| <b>Application Ref:</b>            | 3/2025/0610 |                     |          | <br><b>Ribble Valley<br/>Borough Council</b><br><hr/> <a href="http://www.ribblevalley.gov.uk">www.ribblevalley.gov.uk</a> |
| <b>DELEGATED ITEM FILE REPORT:</b> |             |                     |          | <b>APPROVAL</b>                                                                                                                                                                                              |

| <b>Development Description:</b> | Proposed first floor extension over existing garage. |
| <b>Site Address/Location:</b>   | 26 Woodlands Park, Whalley, BB7 9UG.                 |

First Floor Plan

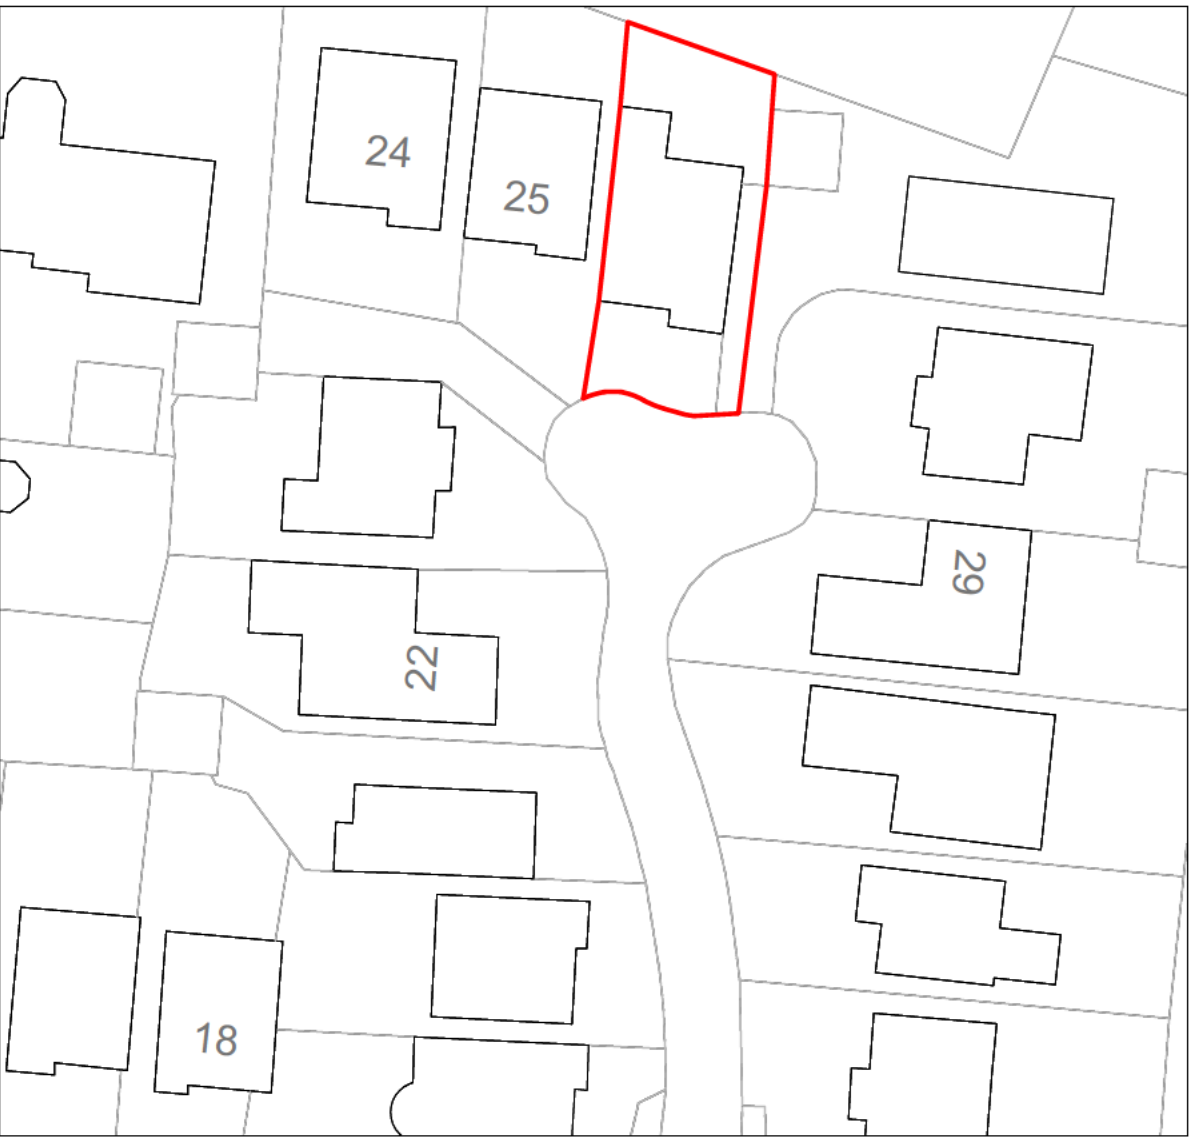
The window openings proposed to the front and rear of the extension would provide similar views to those afforded by the window configuration featured to the existing dwellinghouse and therefore no new opportunities for direct overlooking or loss of privacy are anticipated in this respect. While 1no. window is proposed to the eastern side elevation facing towards the adjacent dwellinghouse at No.27 Woodlands Park, this window is proposed to serve a bathroom and shown to be obscure glazed, mitigating any risk of overlooking.

PROPOSED ELEVATIONS
Scale: 1:100 @A1

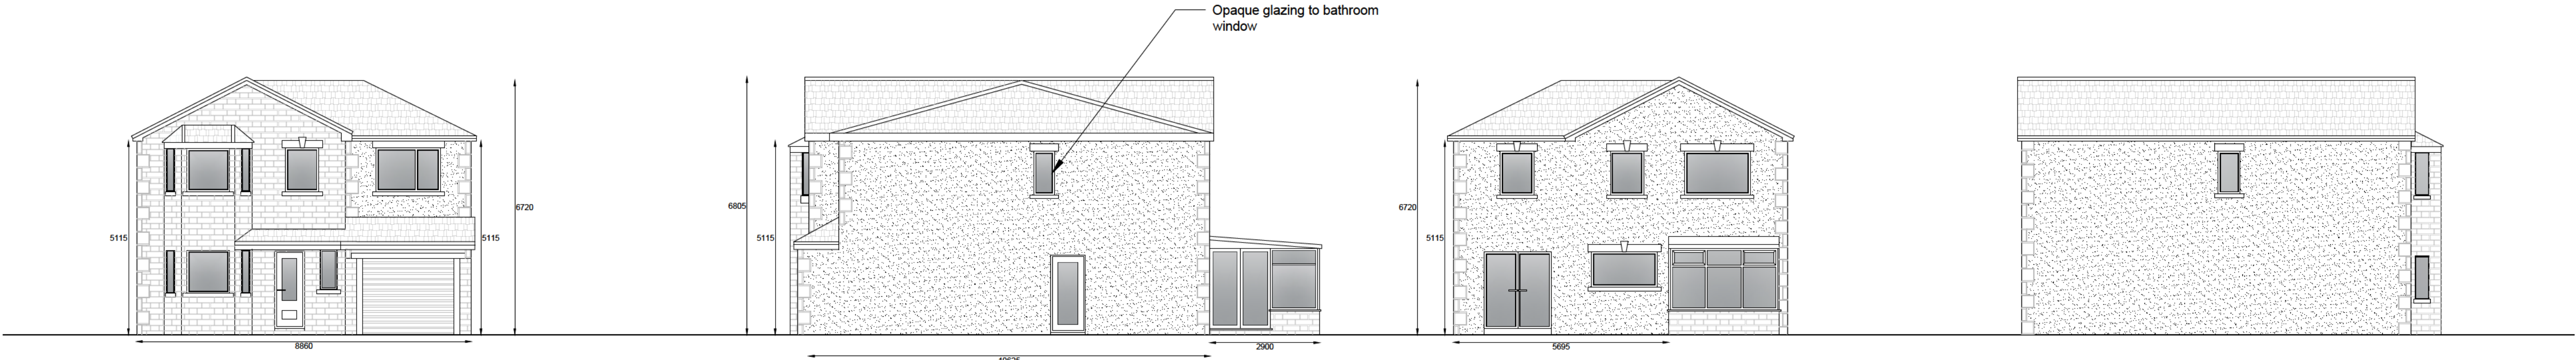
Taking account of the above, the proposed works are considered acceptable with respect to impact upon residential amenity, subject to a condition requiring the window to the eastern side elevation of the extension to be obscure glazed and non-opening.

In most cases, the Local Planning Authority seek to ensure that two-storey/ first-floor extensions are adequately set-down from the main ridgeline and set-back from the principal elevation so as to ensure that the proposal appears subservient to the main dwellinghouse. The extension as originally submitted was proposed to be flush with both the principal elevation and ridge of the primary dwellinghouse. However, following discussions with the agent, the proposal has been amended to include a 0.5m set back. Whilst it is noted that only a marginal set down would be incorporated, the proposal would be adequately set back from the principal elevation so as to ensure that the development reads as a subordinate addition to the parent building. The degree of projection to the side would also not be significant, insofar that the

extension would have a width which is narrower than the existing two-storey dwellinghouse. In this respect, the amended scheme would not appear an overtly incongruous or over dominant addition to the application property or wider street scene.
